S6/2010/0134/FP.

Sent: 05 March 2010 11:36  
To: Planning  
Subject: Comments Added: TWELVE APOSTLES CHURCH, KENTISH LANE

Application ID: S6/2010/0134/FP - Mr P Jefcoate Application Owner: Welwyn & Hatfield Borough Council (Development Control Officer)  
Applicant: D.MARTYN SMITH  
Location: TWELVE APOSTLES CHURCH, KENTISH LANE Deadline Date: 11/03/2010 00:00:00  
Description: REPLACEMENT FENCING TO BOUNDARY

WOODFIELD LANE ELEVATION
PROPOSED NEW RAILINGS
1:75

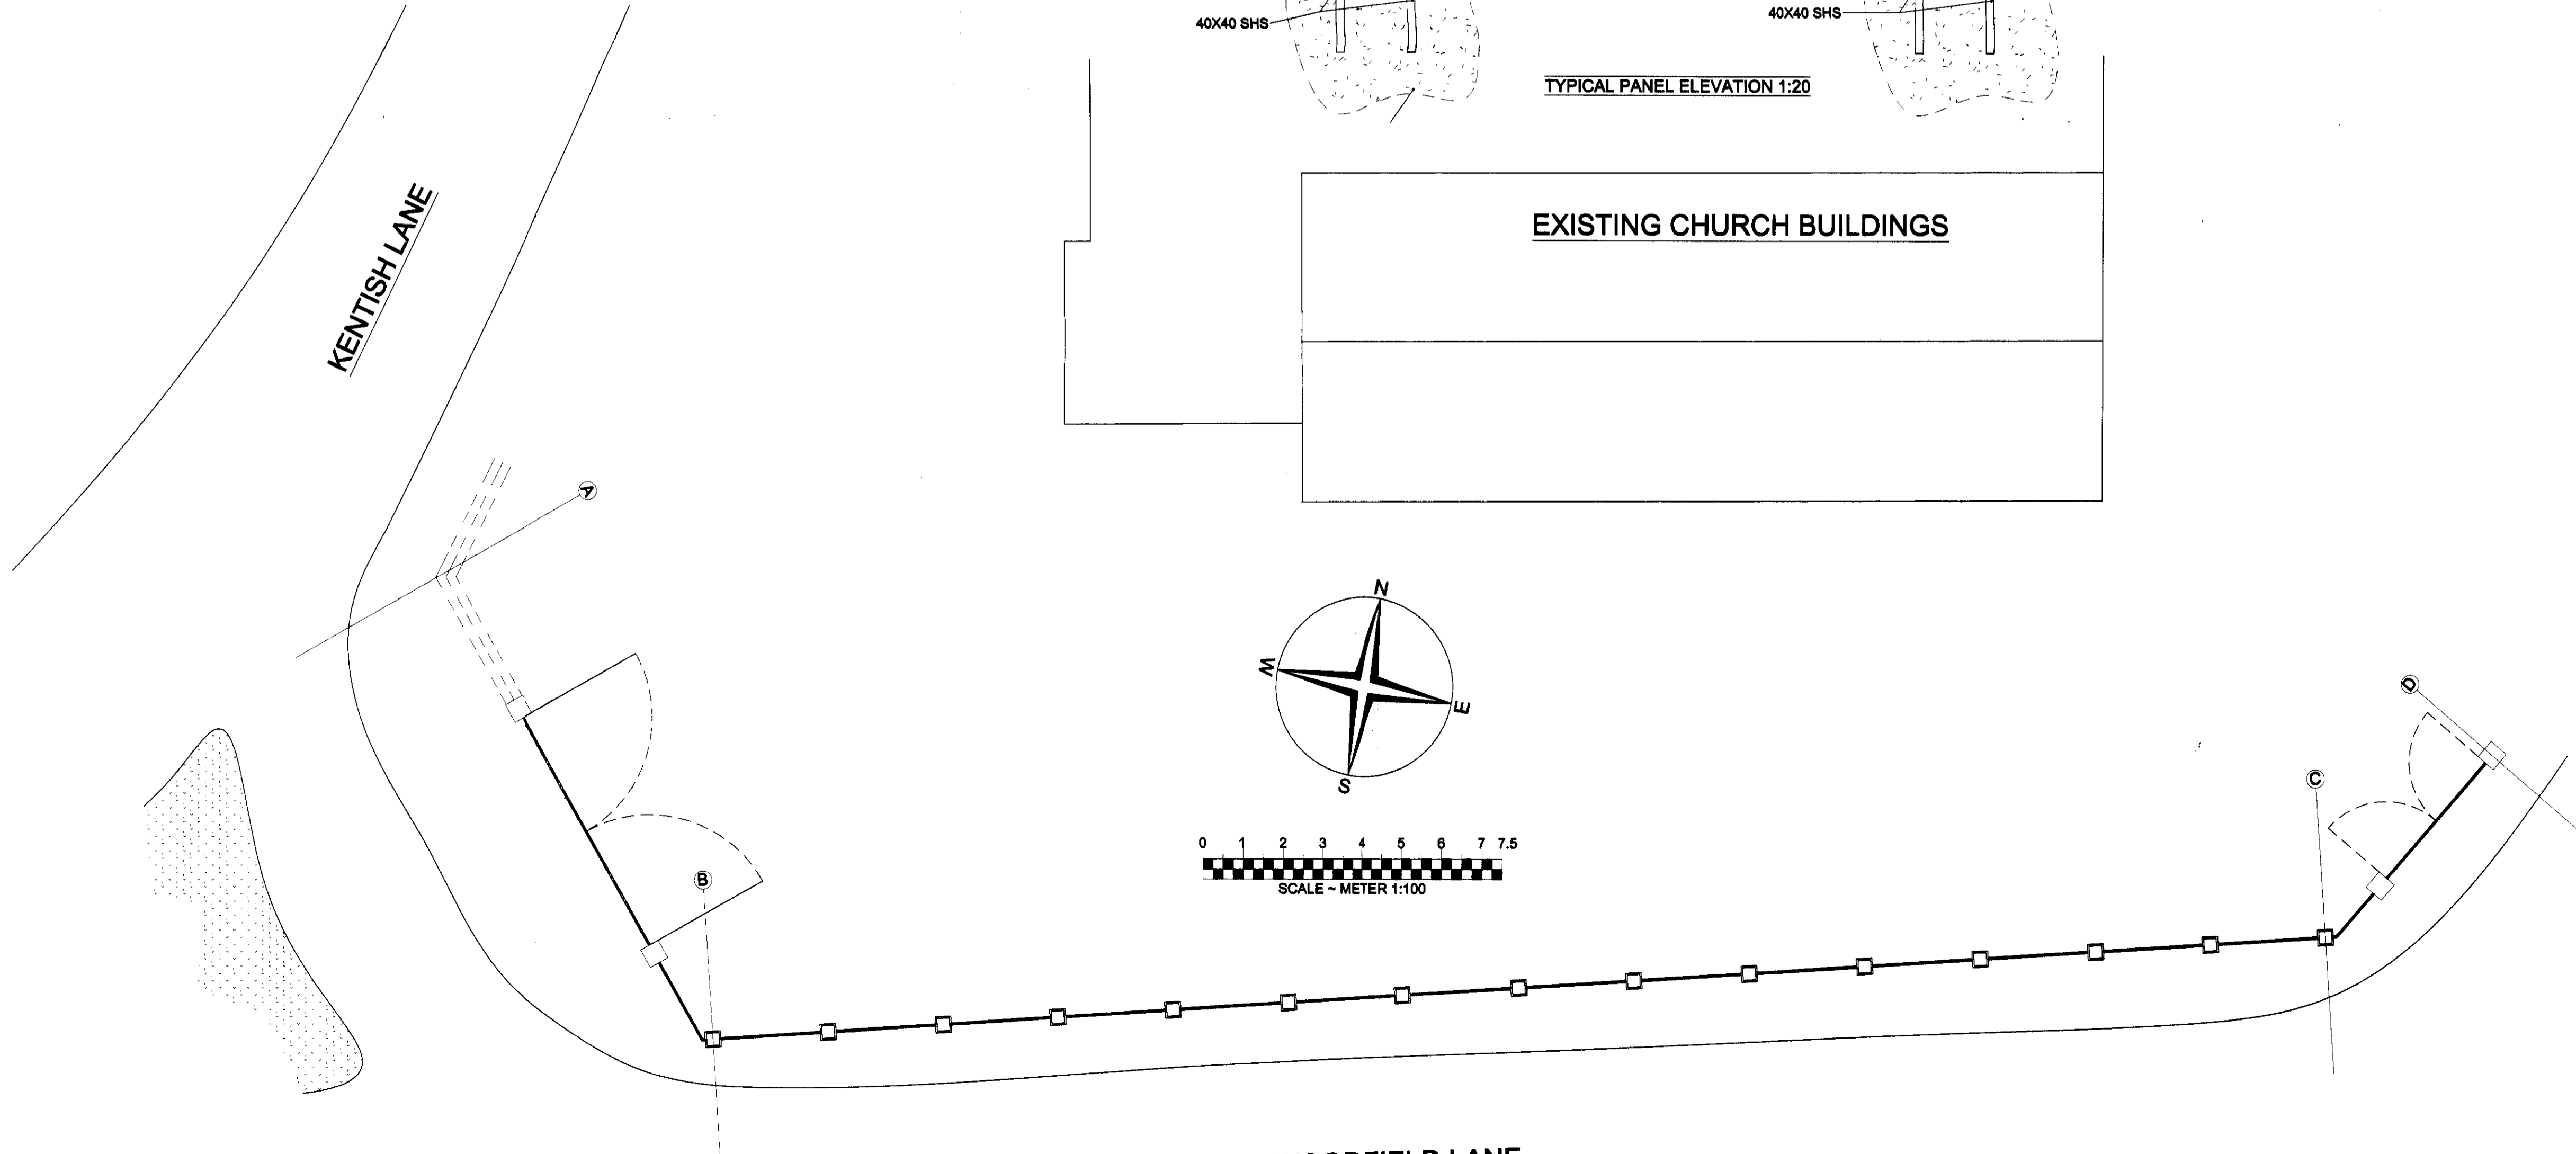
Comment: Hatfield Town Council object to the application considering the wall should be reinstated and not replaced with a rail fence that would be totally out of keeping with the existing church and churchyard.
